Technical note

Project name	Land South of Dearne Valley Parkway		
Design note title	Response to BMBC Highways Development Control		
Document reference	3465		
Author	RJ / AS		
Revision	1.0		
Date	27 June 2024	Approved	<input type="checkbox"/>

This note sets out a consolidated response to consultations from BMBC Highways Development Control on the above planning application in February and May 2024, in accordance with subsequent discussions between the applicant team and BMBC officers.

Drawing Number: **23451-HYD-XX-XX-DR-D-0105** Revision: **P5**

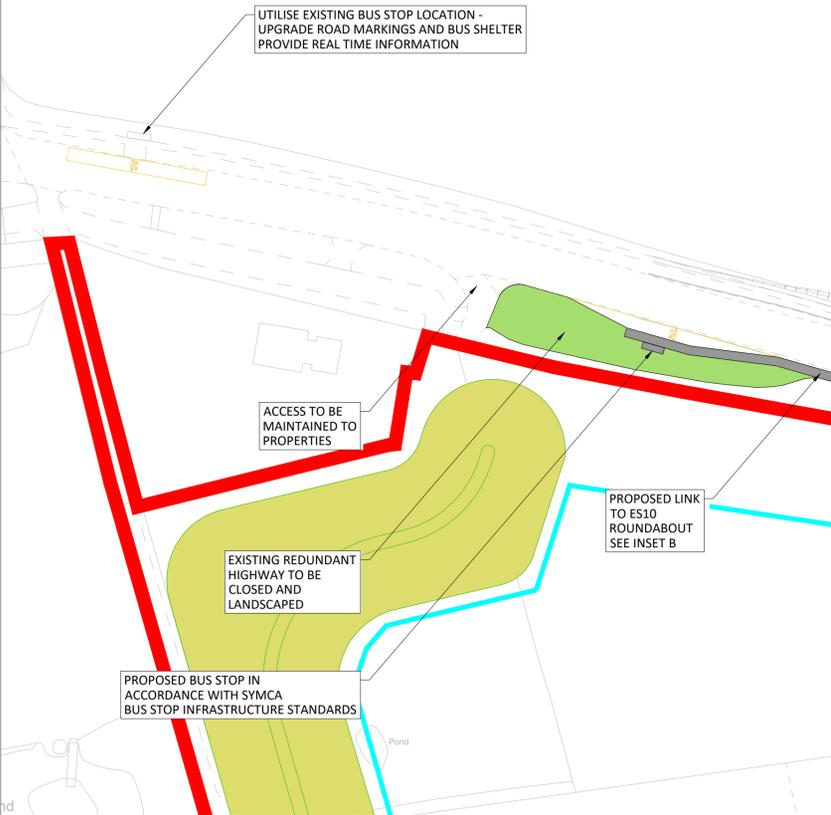
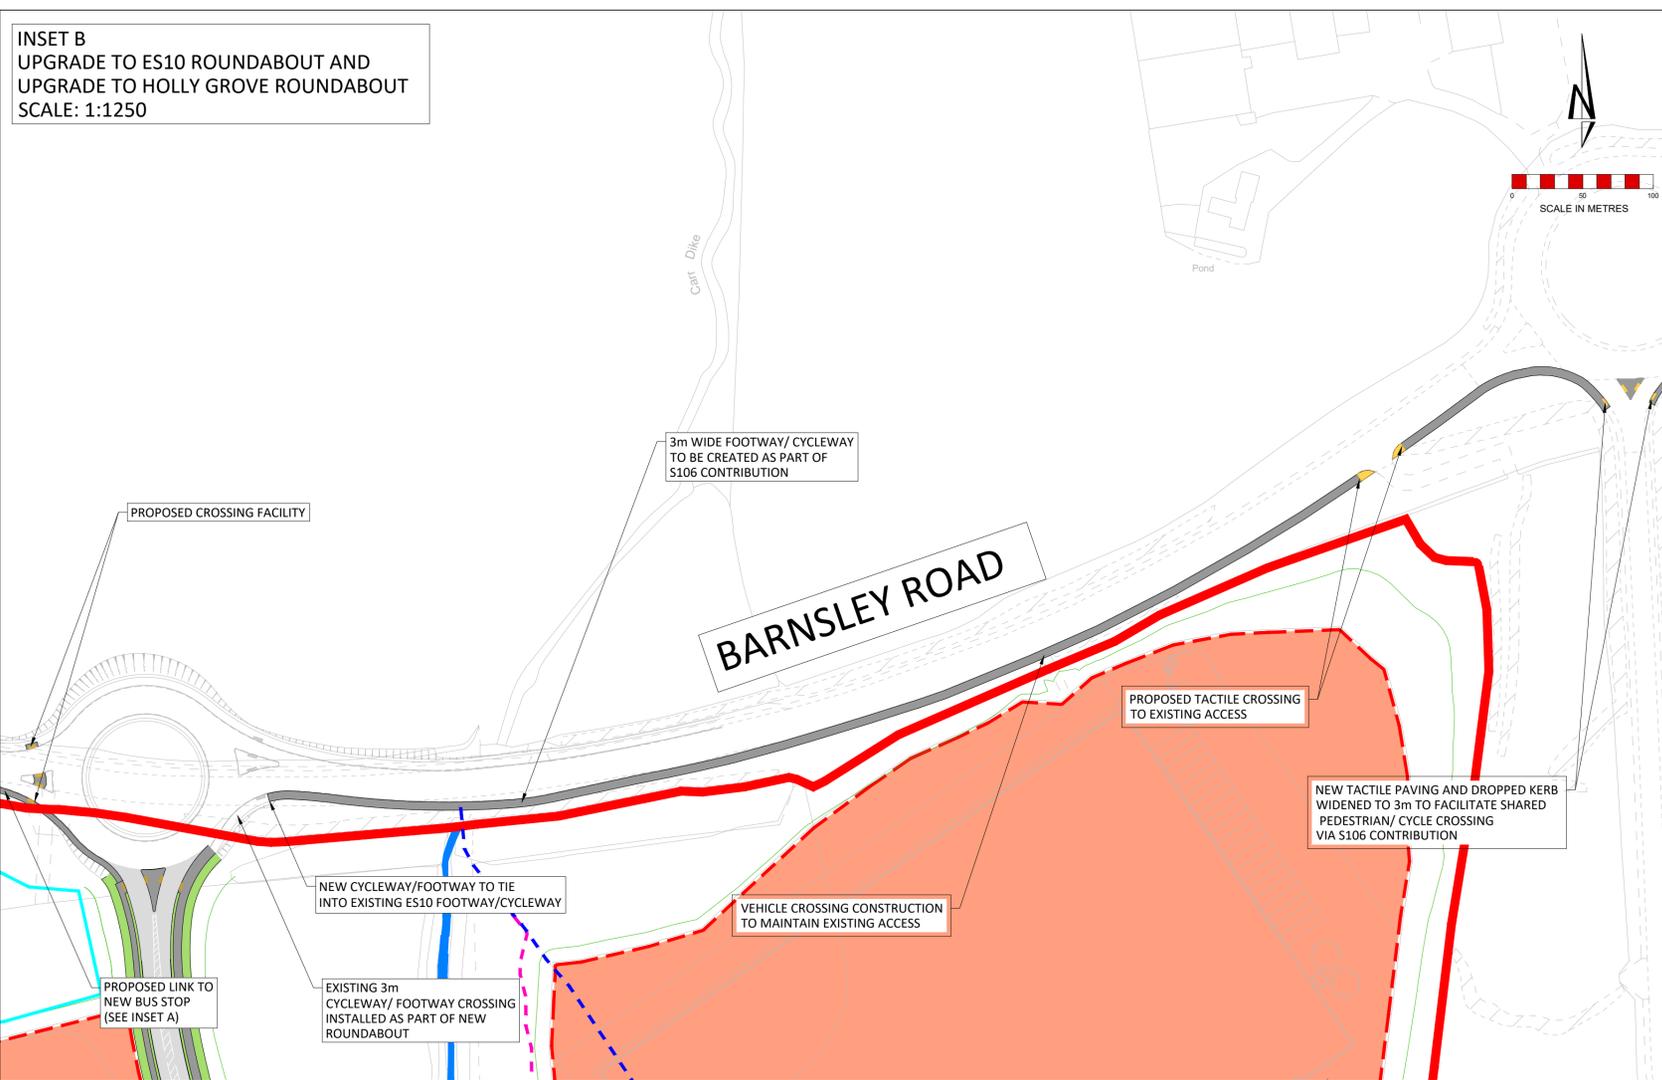
Details of public rights of way are only shown indicatively on Phasing Plan 2 of 2 appended to the Transport Statement. The applicant is intending to only provide full details of vehicular access as part of the full application element of this hybrid submission. However, Highways DM would contend that all access methods should be provided in detail at this stage to ensure that it is feasible to provide suitable access and that the provision is such that it will encourage commuters to use sustainable transport methods to bring about the 10% reduction in private car use cited in the Travel Plan.

It is noted that there are ongoing discussions regarding covenanted land and a proposed footpath in the north-western corner of the site. Highways DC would prefer to see a footway provided contiguous with the A635 which can be adopted and maintained in perpetuity. This should extend from the new roundabout to the bus stop approximately 150m to the west.

1) Improvements to Definitive Footpath 15 to provide a shared-use path with a minimum width of 3.0m to allow use by pedestrians and cyclists.

This element has been requested by Active Travel England, and the Council's Active Travel and PROW departments. It is also noted in National Highways formal response that the path is presently too narrow to cater for anything other than pedestrians. The improvements will require a detailed design to be submitted to be assessed by the Council's Traffic and PROW engineers.

Revised drawings demonstrating access routes by pedestrians and cyclists are submitted to BMBC. These comprise:

- » Proposed improvements to Footpath 15, and connection to the internal access road within the development site, to allow shared use by pedestrians and cyclists and support its use as an active travel connection to the development from Carr Field Lane / Billingley View, for potential future staff travelling between the site and residential areas in Goldthorpe and Bolton upon Dearne.
- » Access routes to the A635 to the north of the site, including a new section of footway along the southern edge of the carriageway to the westbound bus stop on the A635, and crossing provision over the splitter island on the western A635 arm of the roundabout (linking to the shared use footway / cycleway on the northern edge of the A635).

This connection is demonstrated on revised drawings submitted to BMBC.

It is proposed that the section of Footpath 15 and the proposed connection to the internal network of pedestrian / cycle routes within the site is improved, to accommodate a minimum width of 3.0m width and support shared use by pedestrians and cyclists as requested. This is demonstrated on drawings submitted to BMBC.
